SUBJECT: Engineering Review Comment
Mountain View Electric Association Inc. (The Association)

Project Name: Sunrise Meadow Subdivision Filing 2 - Lot Line Adjustment
Project Number: VR217
Description: A replat of lots 2, 3 and 4 located off Poco Rd. and Vollmer Rd. in Township 12, Range 65, Section 28.

SUNRISE MEADOW SUB. FIL. NO. 2 - SEC. 28, T12S,
R65W OF THE 6th P.M., EL PASO COUNTY, COLORADO

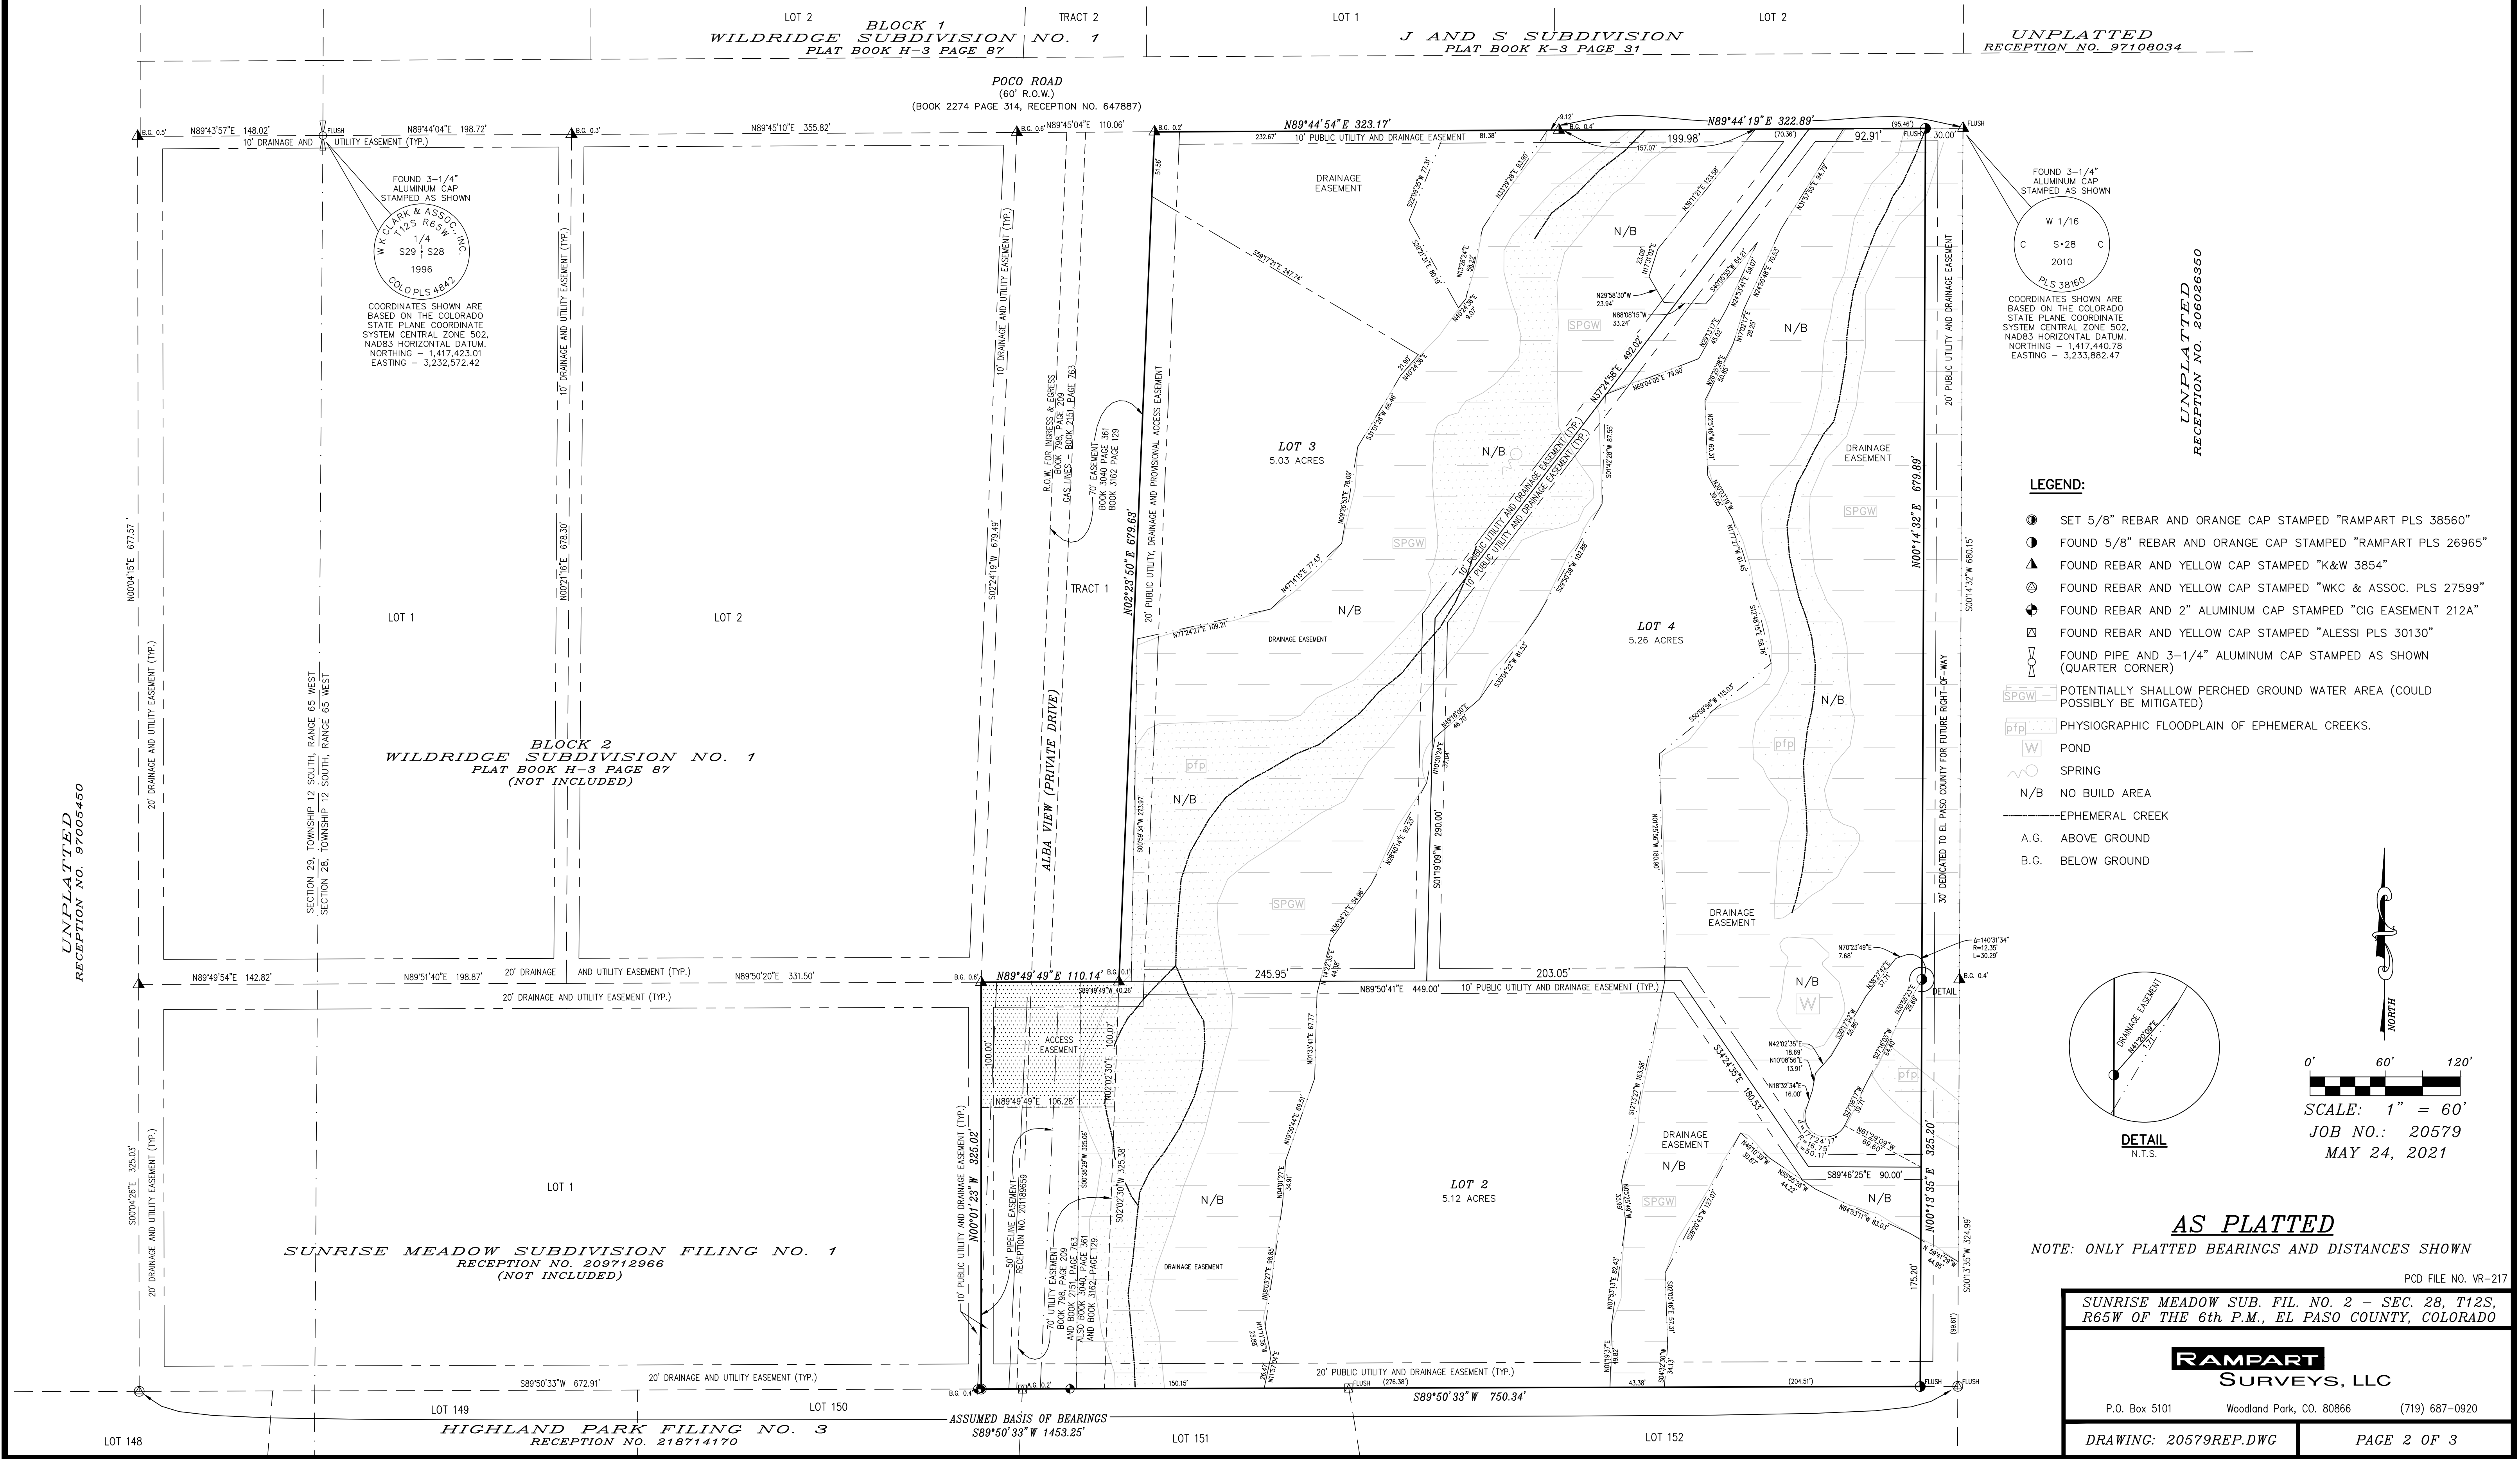
The Association requests a ten (10) foot front, side, and rear lot utility easement on the plat easement along with a twenty (20) foot exterior utility easement. The Association also requests the platting of the Association's existing facilities with easement on the plat. Additional easements may be required.
